Community Services Planning Department

Project Name: [Kroger Fulfillment Center - Site Development Plan](#)
Project ID Number: 2011731

The City of Fountain has completed its review of the Kroger Fulfillment Center - Site Development Plan for the property generally located at 702 BANDLEY DR. The following are items that need to be corrected and/or modified. Once you have made the revisions, please resubmit all project documents through the project portal, using the 'Review and Resubmit' button provided on your project page. Please provide a response to all comments as part of the resubmittal process. You can "reply" on the "response tab".

C-406

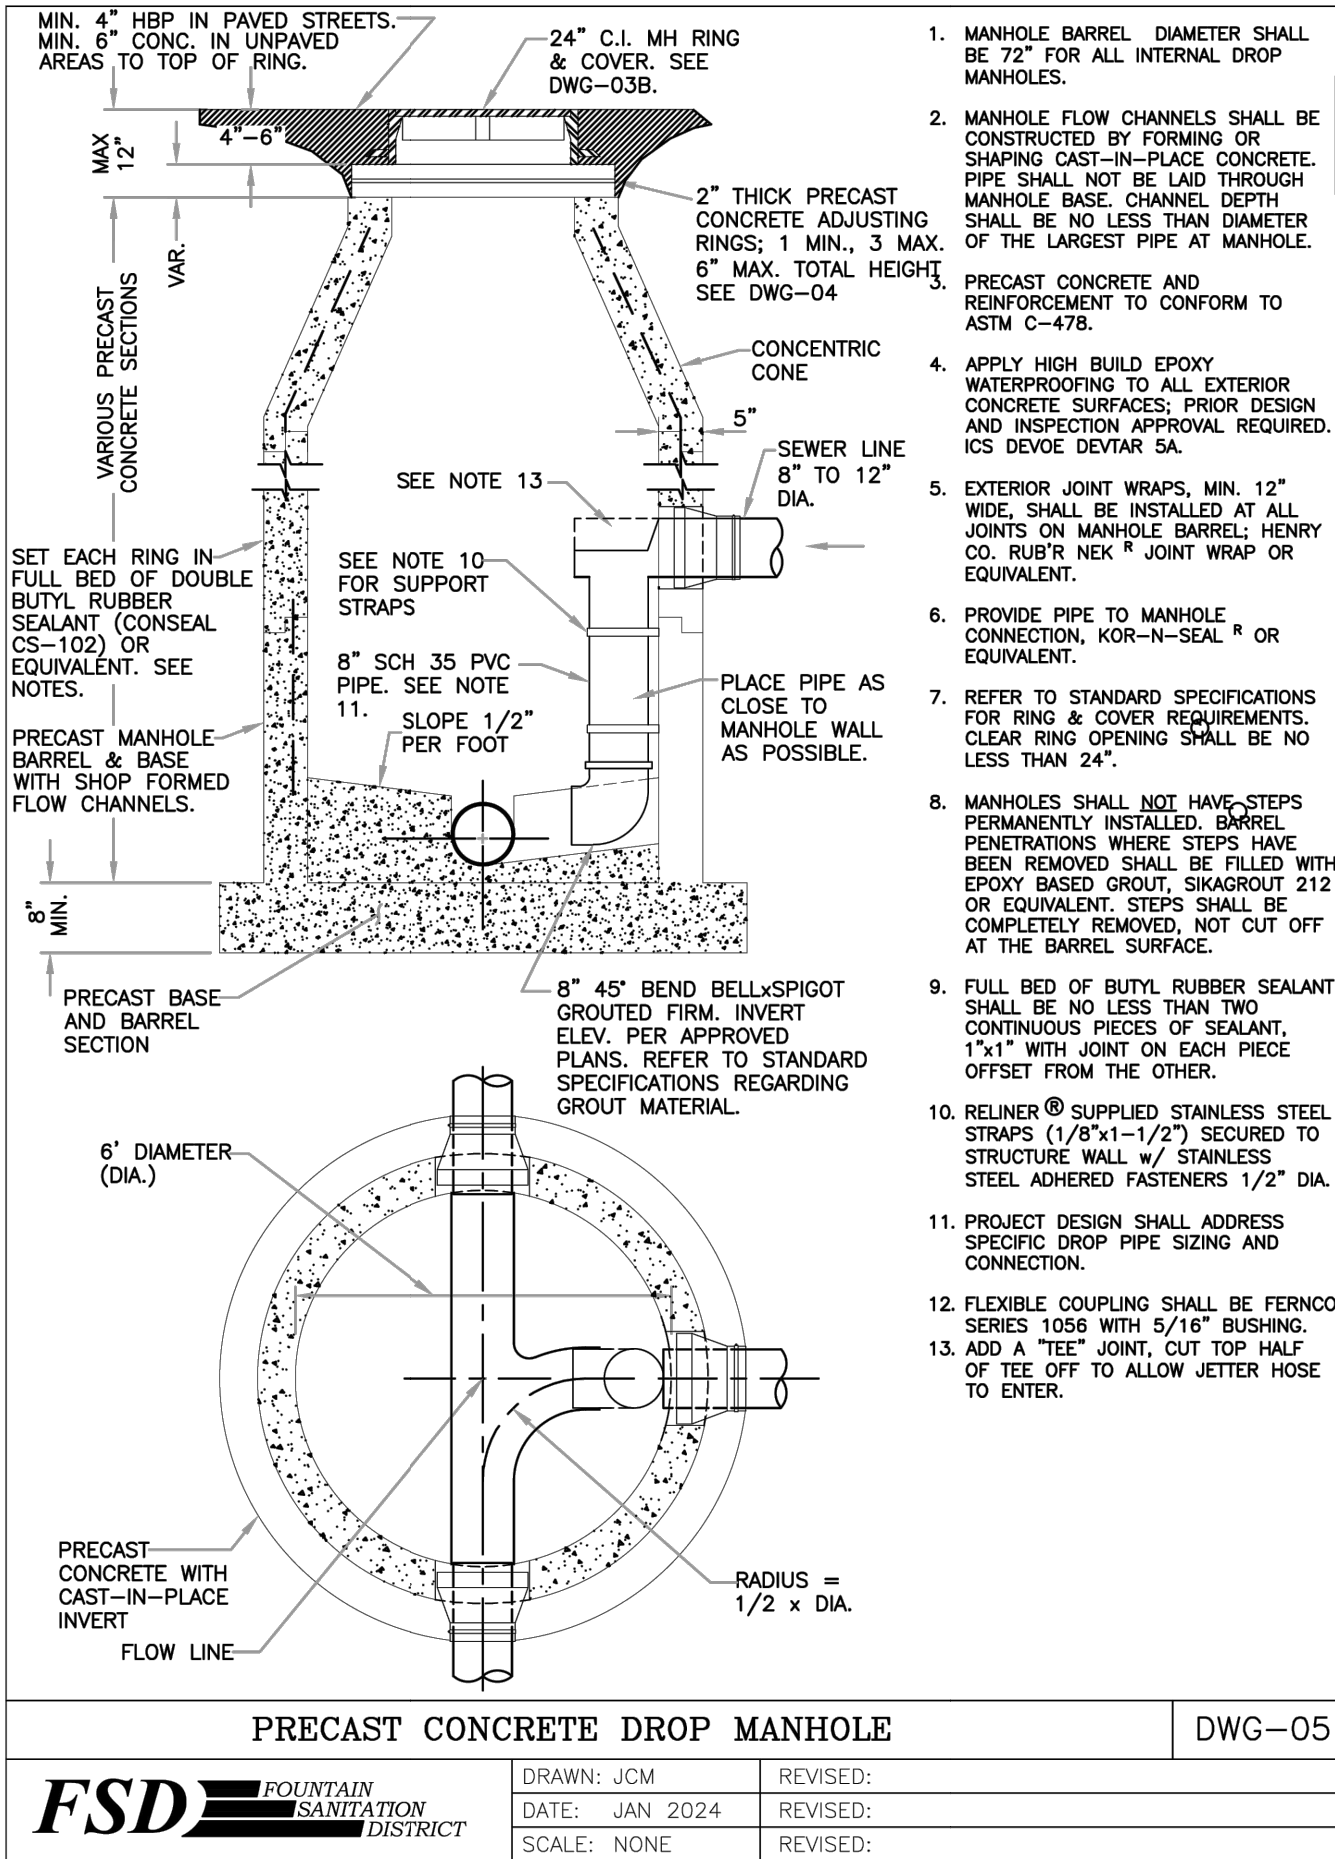
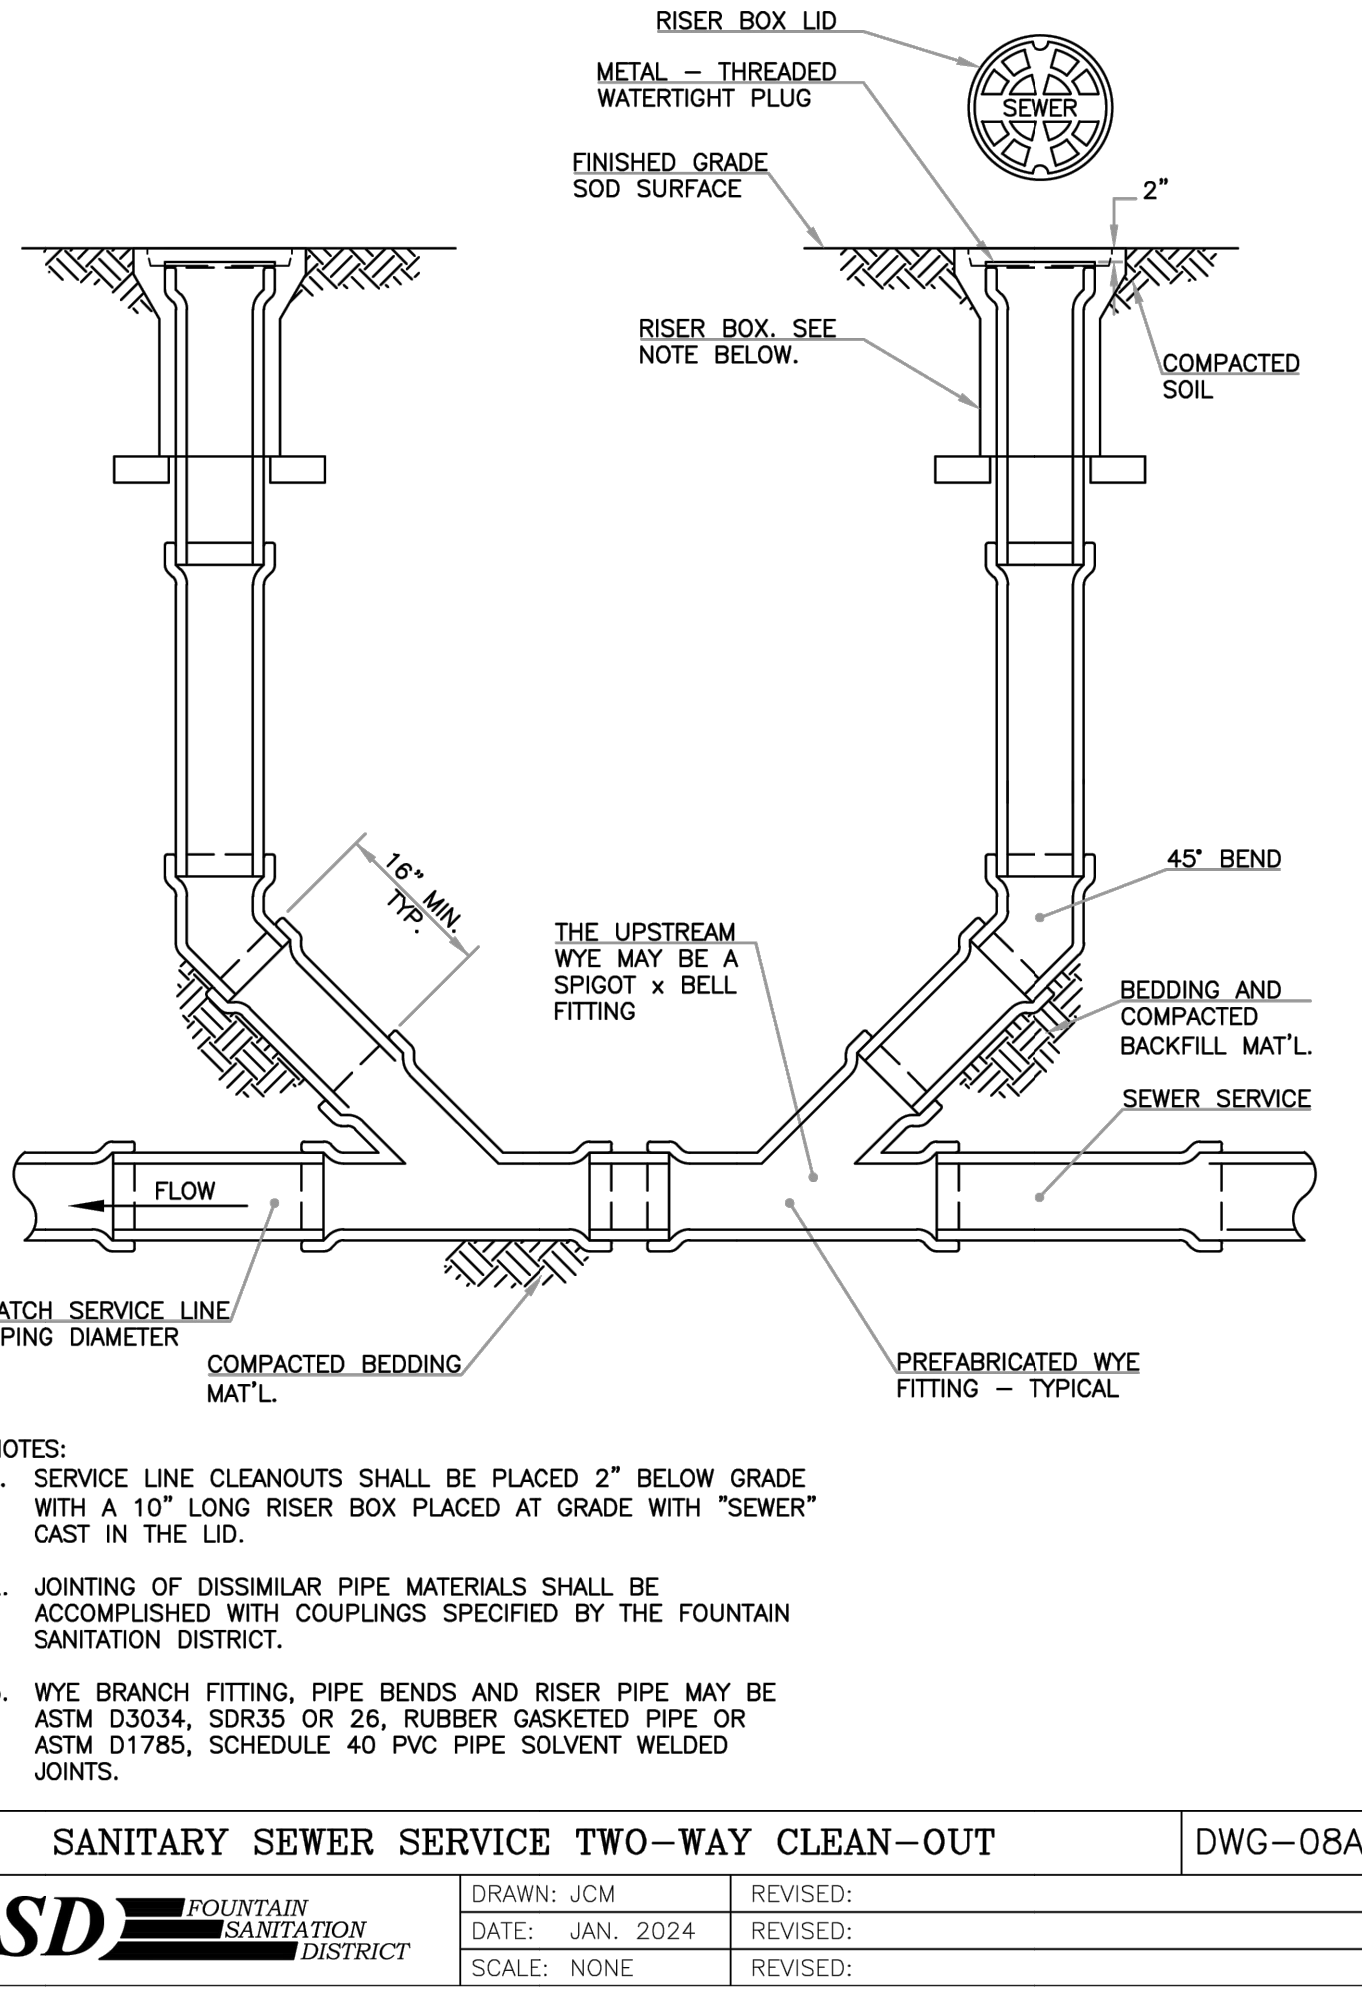
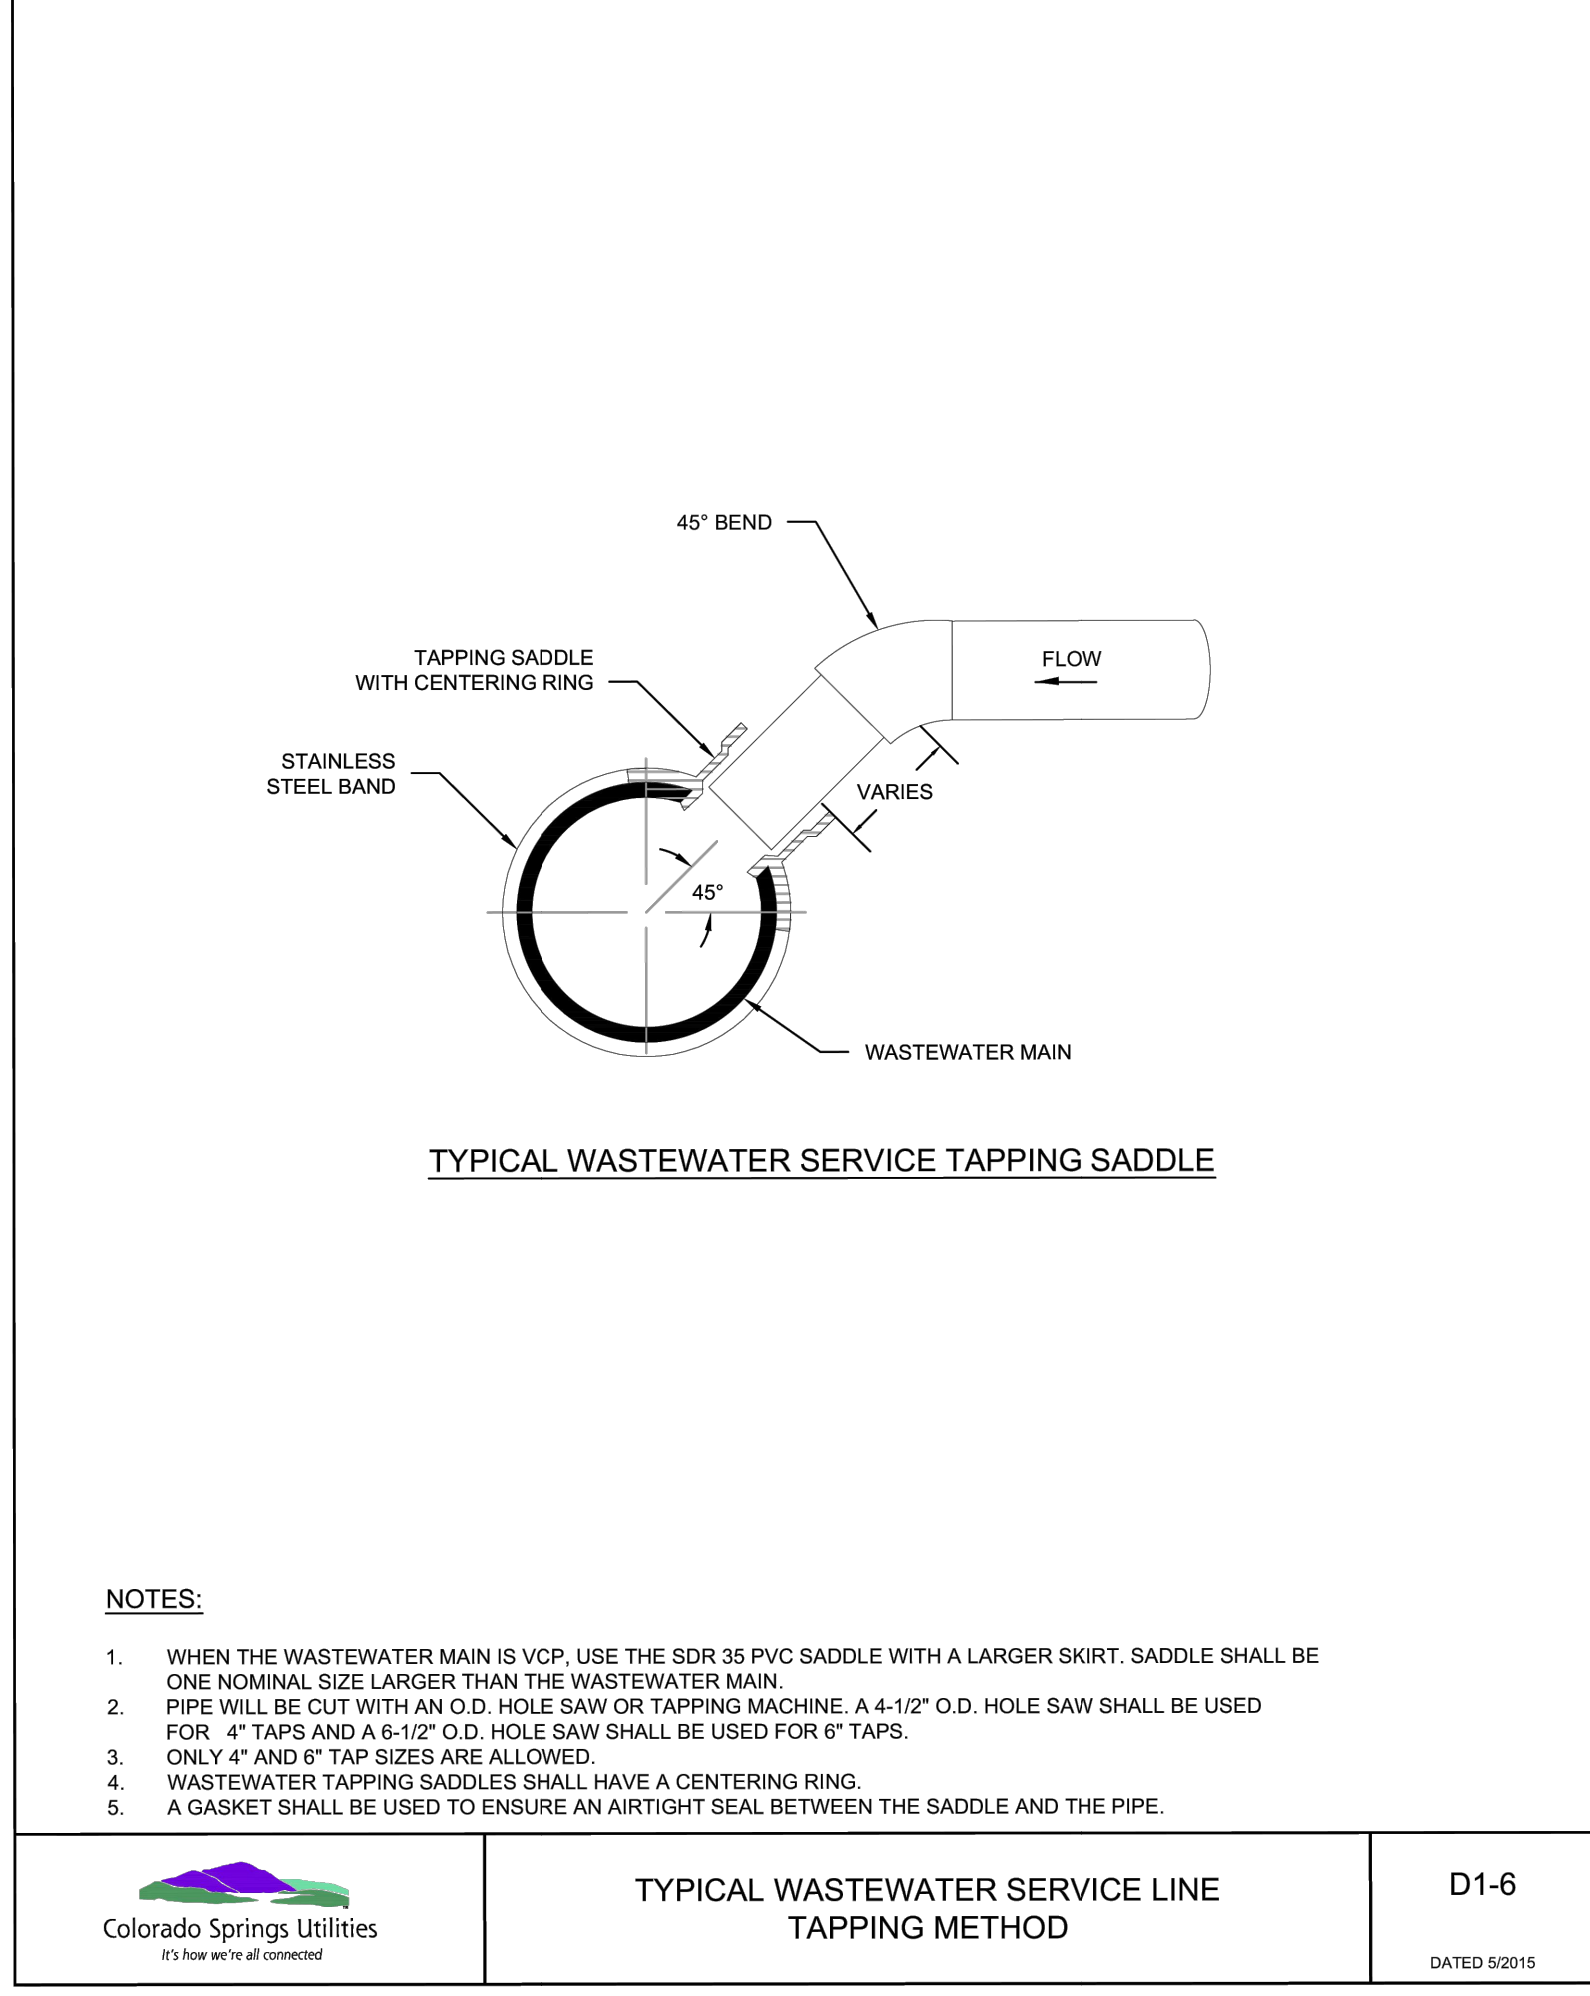
Fountain Sanitation District remove details
Jonathan Moore
7193825303
jonathanm@fsd901.org

Fountain Sanitation District remove and replace with detail DWG-03
Jonathan Moore
7193825303
jonathanm@fsd901.org

Fountain Sanitation District Add FSD detail DWG-08A
Jonathan Moore
7193825303
jonathanm@fsd901.org

Fountain Sanitation District Add detail from Colorado Springs Utilities D1-6
Jonathan Moore
7193825303
jonathanm@fsd901.org

Fountain Sanitation District remove detail
Jonathan Moore
7193825303
jonathanm@fsd901.org
